Subject: Rezoning Petition Review

Rezoning Petition #: 22-117

Location of Property: Approximately 9.16 acres located on the northeast side of Old Plank Rd, east of Brookshire Blvd and west of Harland St.

REZONING PLAN
RZ.01

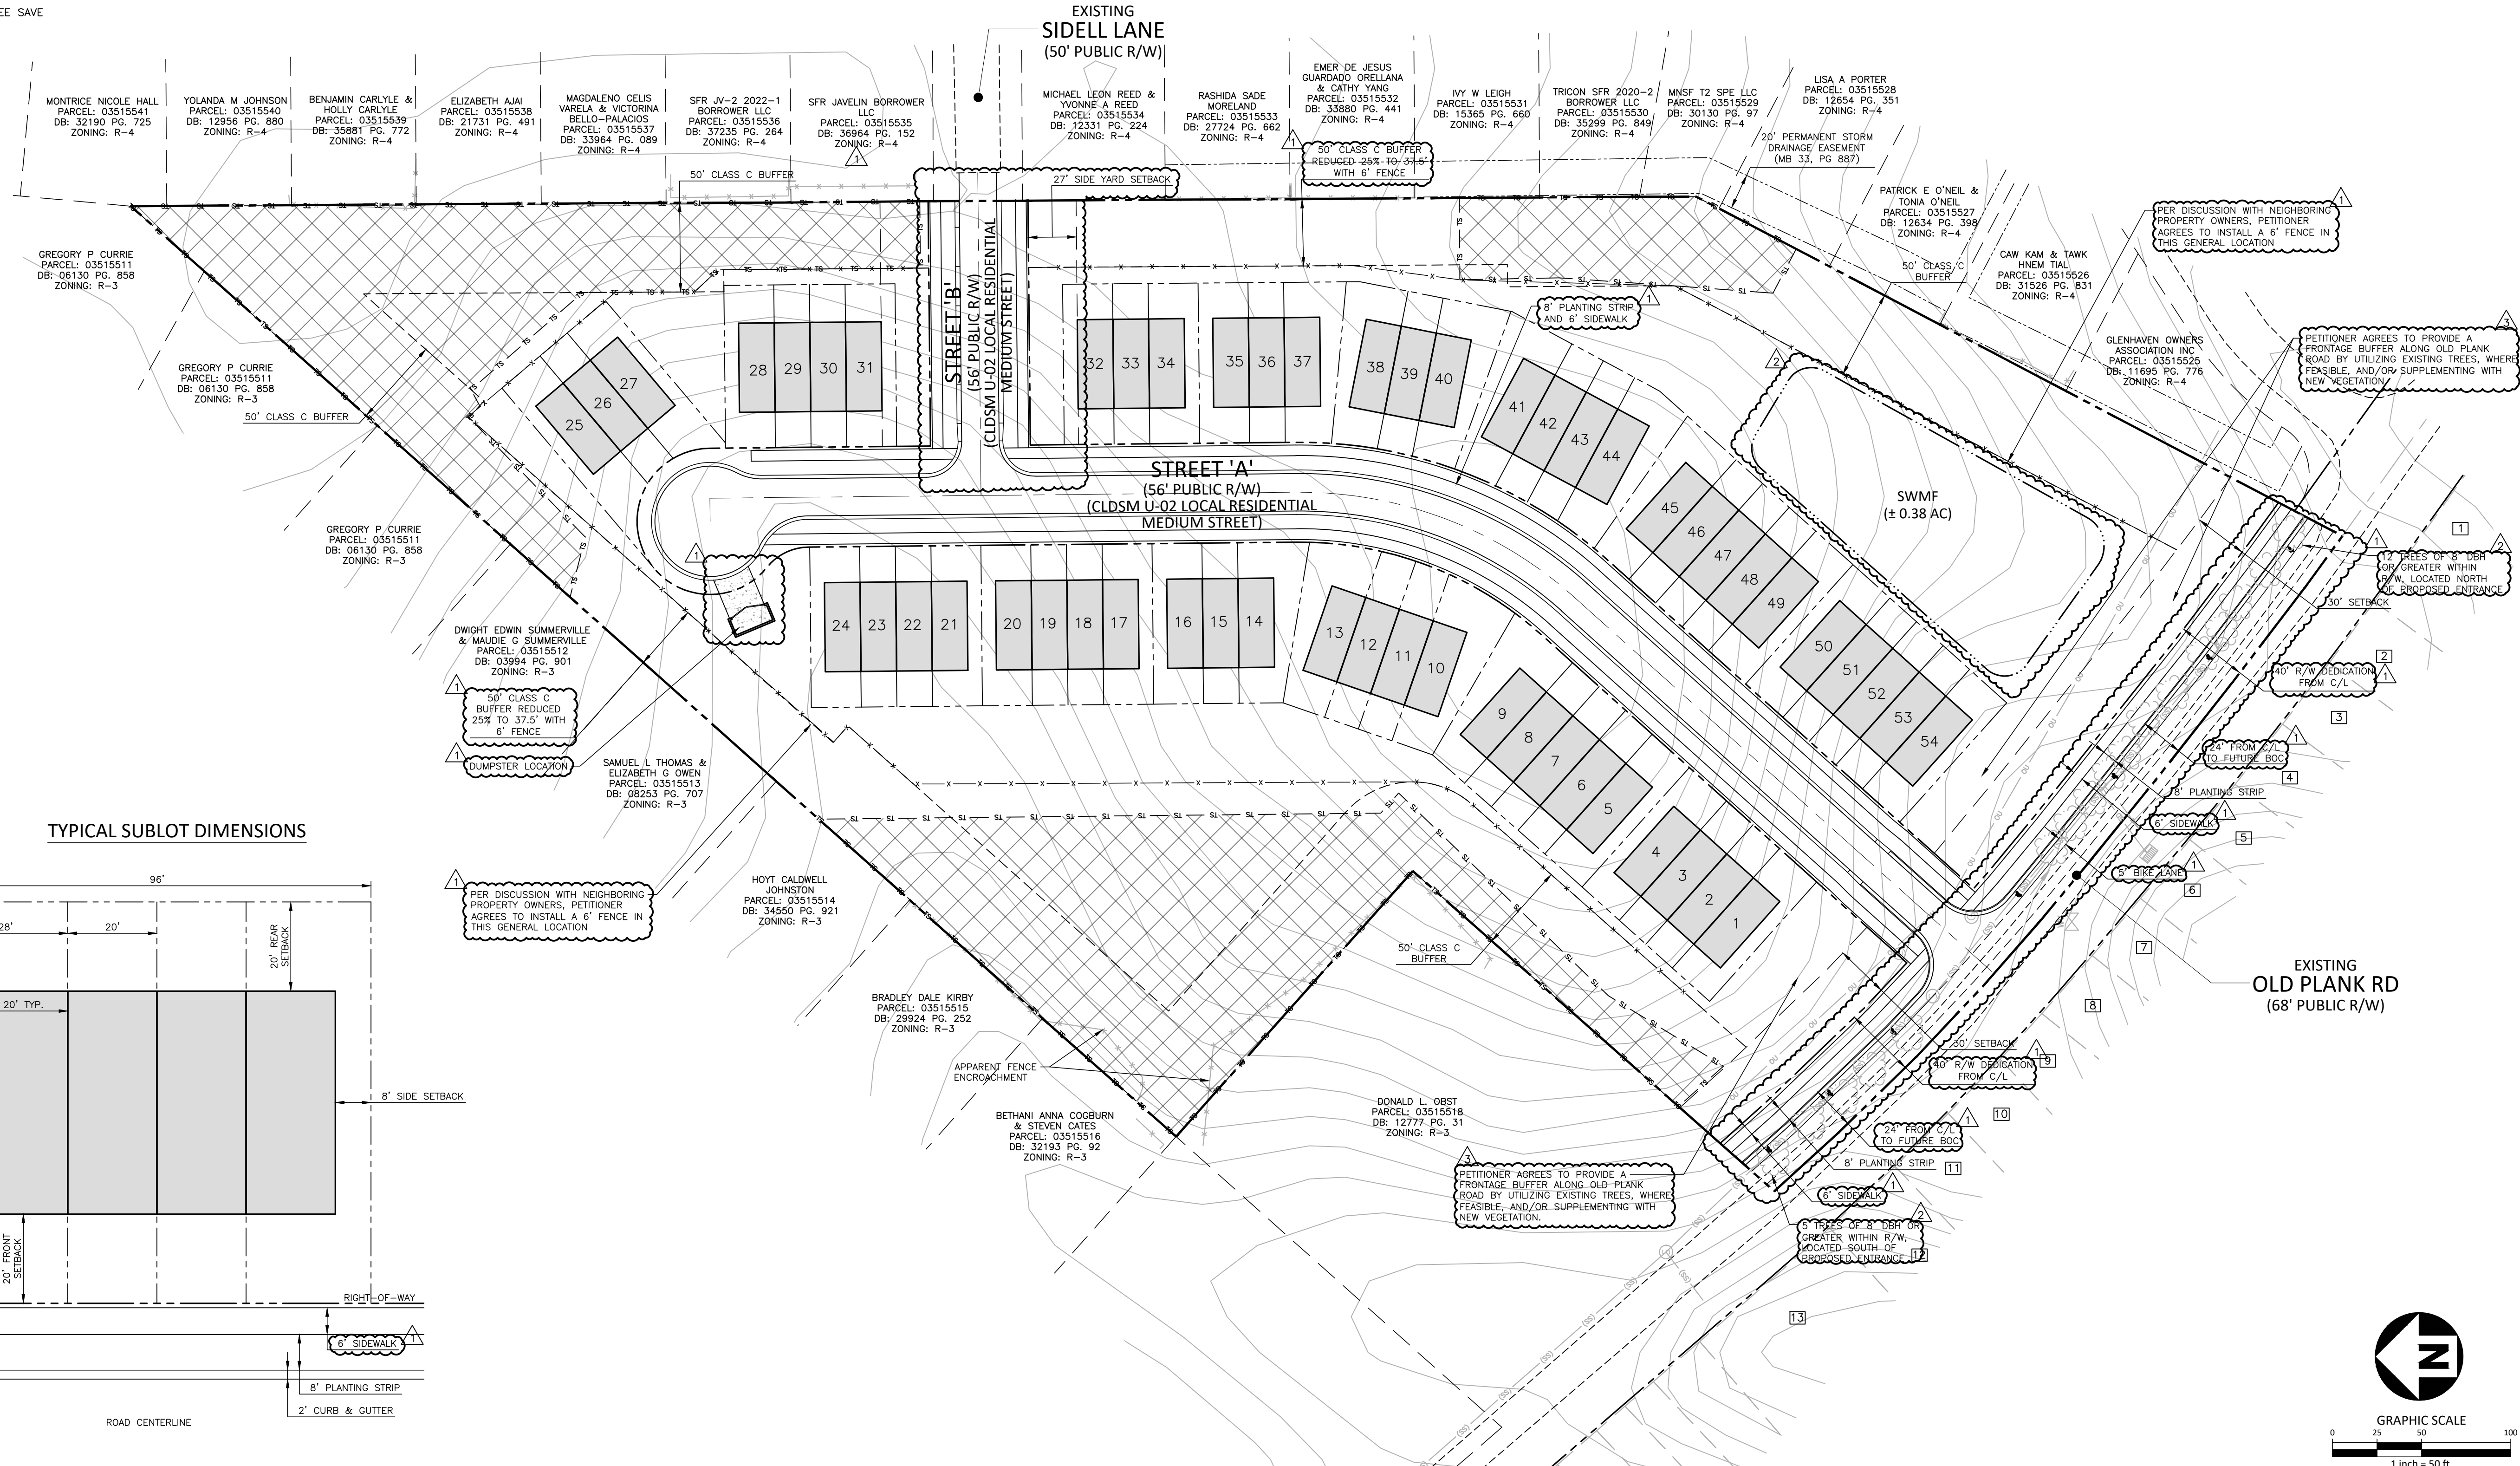
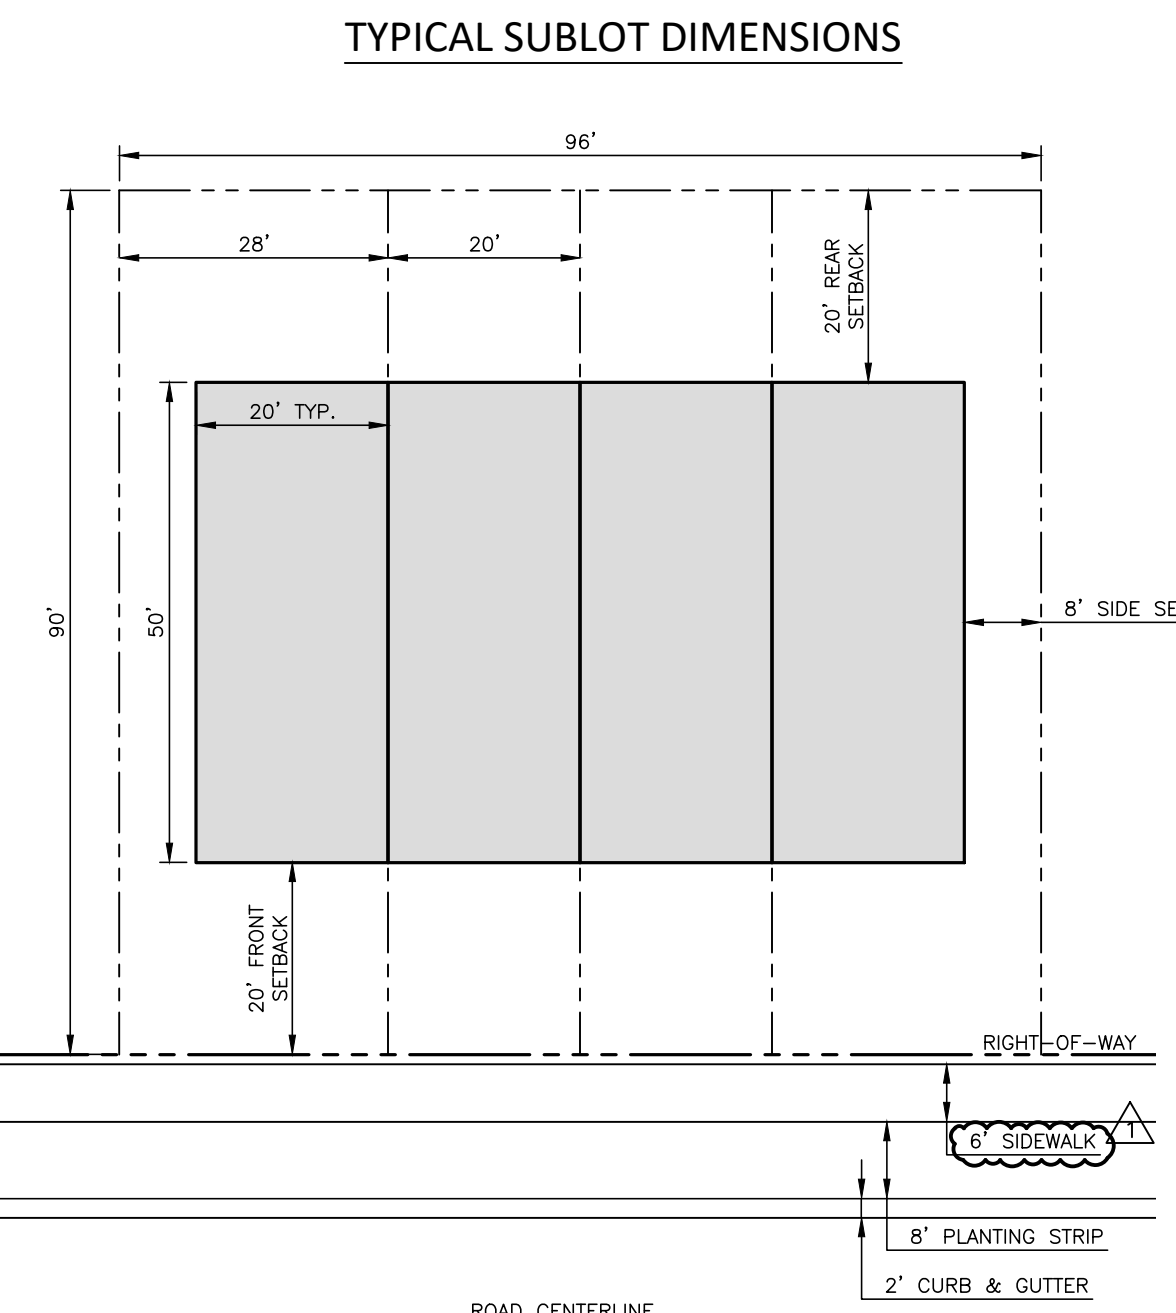
Please include the following note under Environmental Features. *For adjoining parcels receiving storm water discharge the petitioner shall analyze the adequacy of the existing storm water conveyance on the adjoining parcels to Sampson Street. If the existing storm water conveyance on the adjoining parcels is found to be inadequate, the Petitioner shall make a good faith effort with the property owner(s) to improve the storm water conveyance or mitigate the storm water discharge onto the adjoining parcels.*
